Regarding planning permission

No 3/2023/0105

Ground Floor Plan

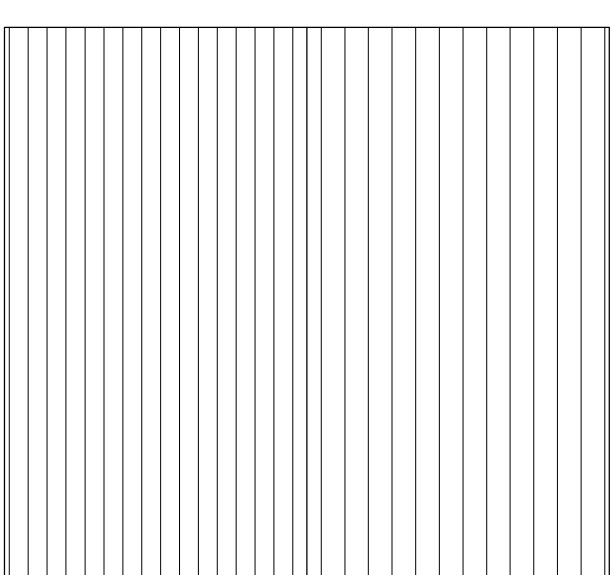
1). There is already planning permission for a large garage at the side of the property and now planning permission is being sought for a large garage with 3 windows a front door and a bathroom so I would query its usage as a garage.

Roof Plan

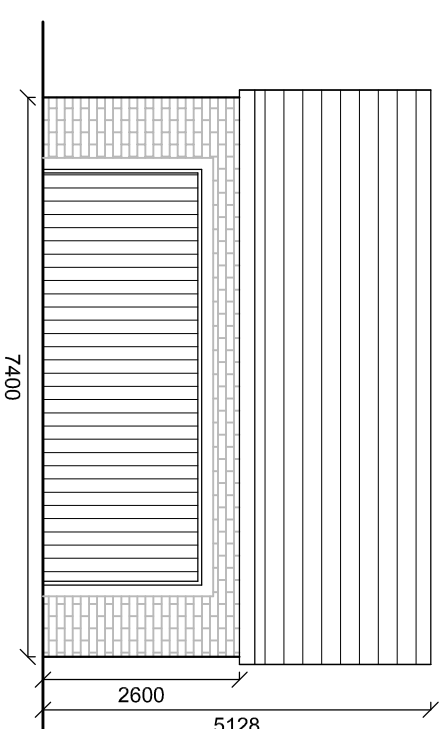
3). The request for increased roof height with skylights would result in loss of privacy
